Subject: RE: Y/99/20/PL Bonhams Field

Engineers Comments Regarding Surface Water Drainage

Area of Junction Works drawing 23018/102

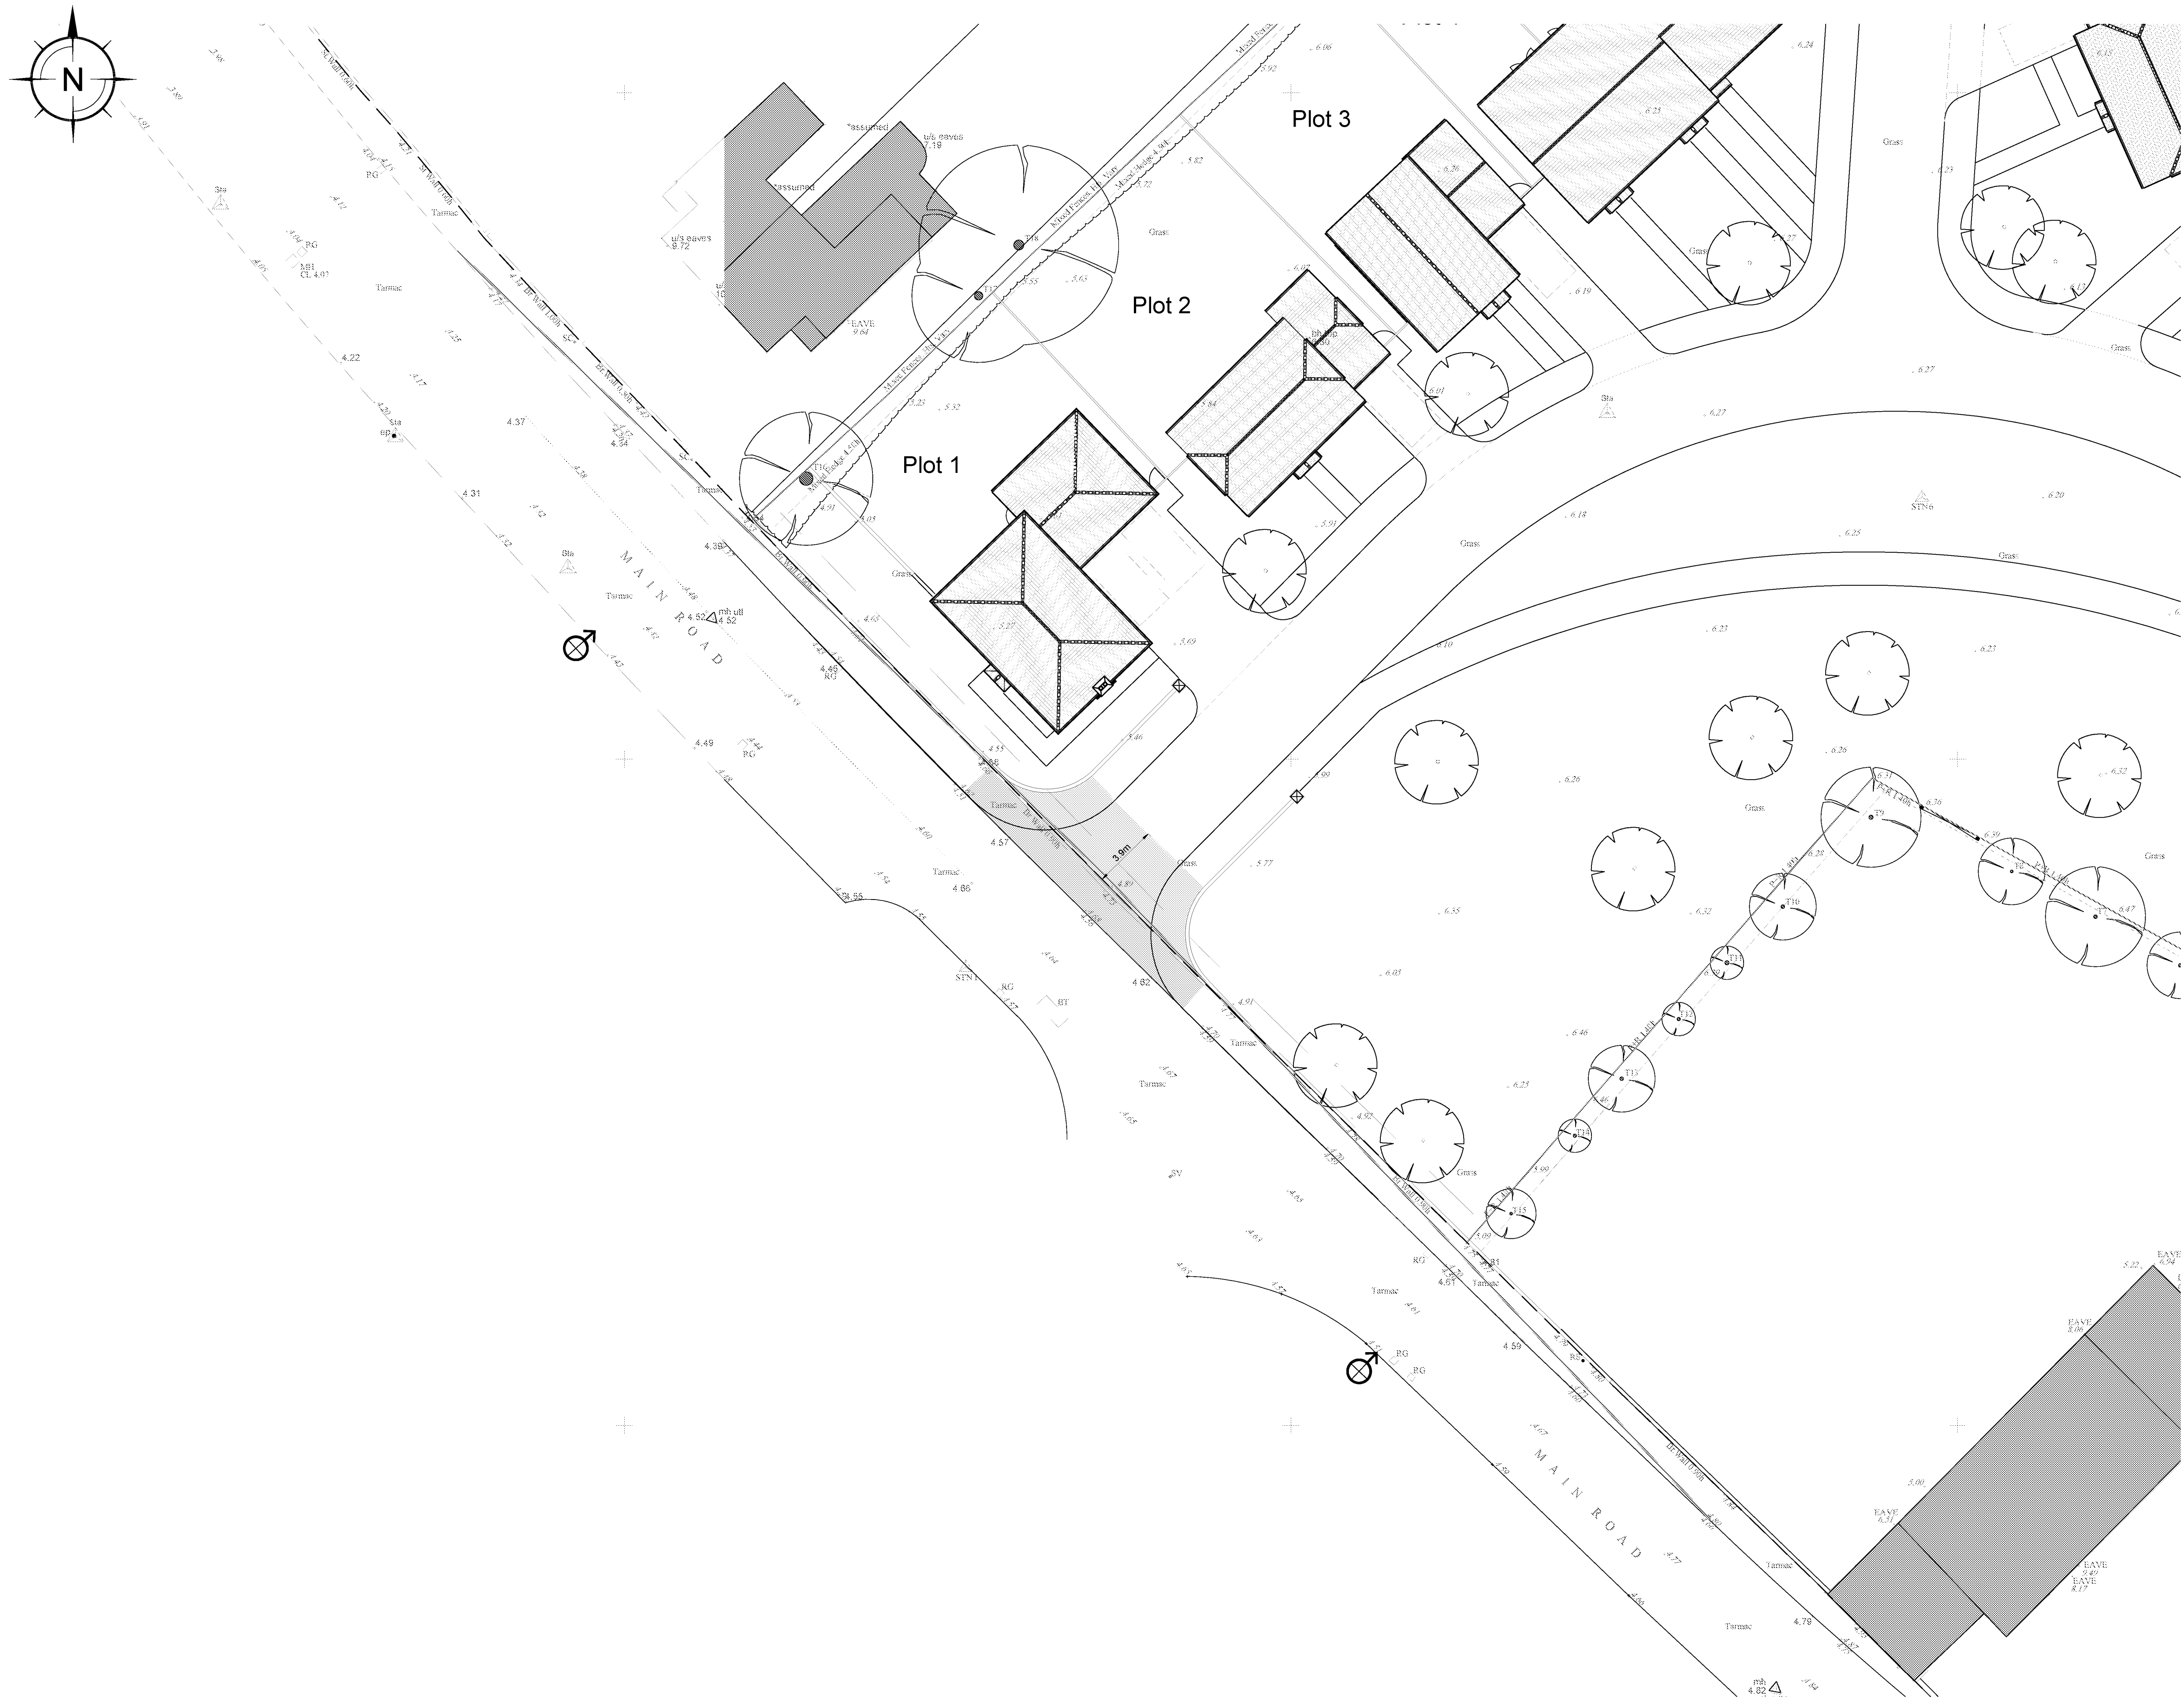
We do have some concerns regarding this application to vary the drainage conditions. The area in the plan referenced within the proposed condition rewording is part of the wider surface water drainage storage area for this site. This area should have a permeable construction. Please can the applicant submit a detail evidencing that this will be the case. This is required to ensure that the access way will not result in highway flooding.

It may be that the access way will have to be reconstructed if the drainage strategy is changed substantially. Please can the applicant acknowledge that if necessary they would make any necessary adjustments to the construction after agreement of the drainage strategy.
